MOOLARBEN COAL COMPLEX UG1 OPTIMISATION MODIFICATION RESPONSE TO SUBMISSIONS

7 SEPTEMBER 2015 Project No. MCM-14-05 Document No. 00689205

Figure 3: Groundwater Monitoring Network

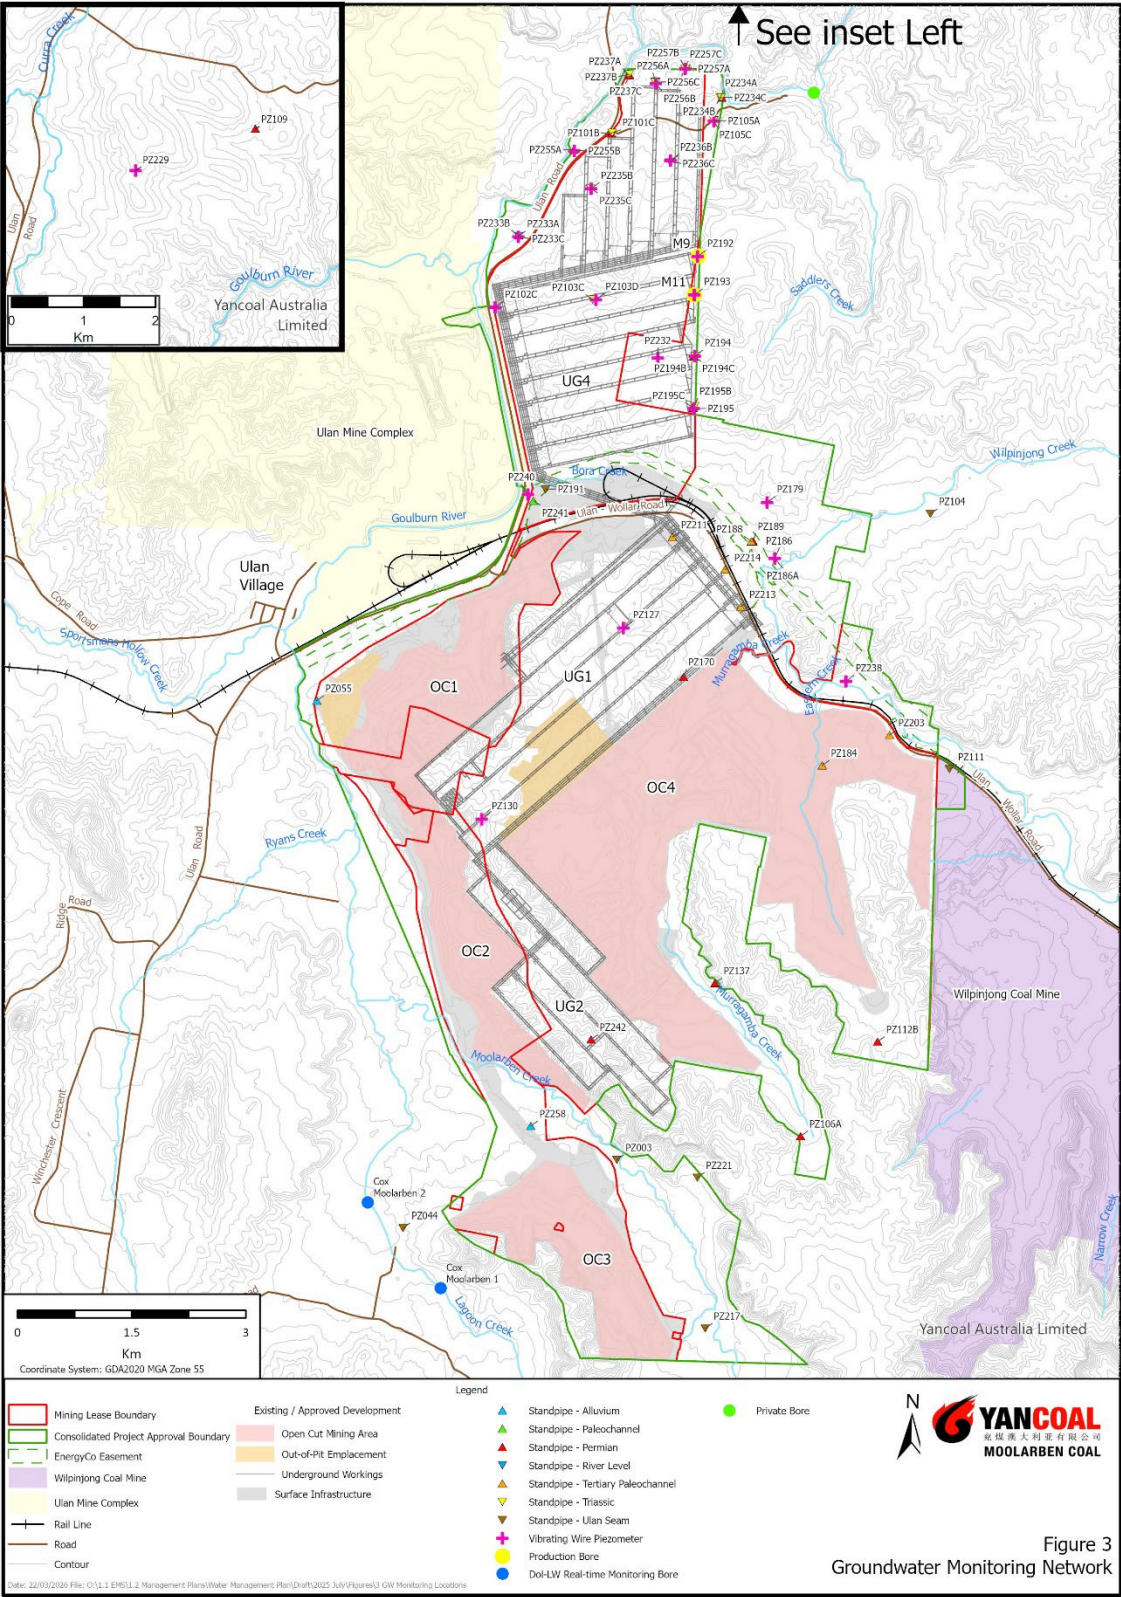
DPI Water requested a figure of registered bores in the vicinity of the Moolarben Coal Complex.	Figure 3 of the approved Groundwater Management Plan includes the location of private bores. The Groundwater Management Plan is available on MCO's website: http://www.moolarbencoal.com.au/licences-approvals/management-plans/ .
DPI Water advised that any bores for the purpose of mine dewatering require a licence under Part 5 of the <i>Water Act</i> , 1912.	Noted. MCO will apply for any necessary licences required under the Water Act, 1912 for the Moolarben Coal Complex.
DPI Water noted the combined impact of the existing approved development and Modification are within minimal harm considerations for water table and water pressure.	Noted.
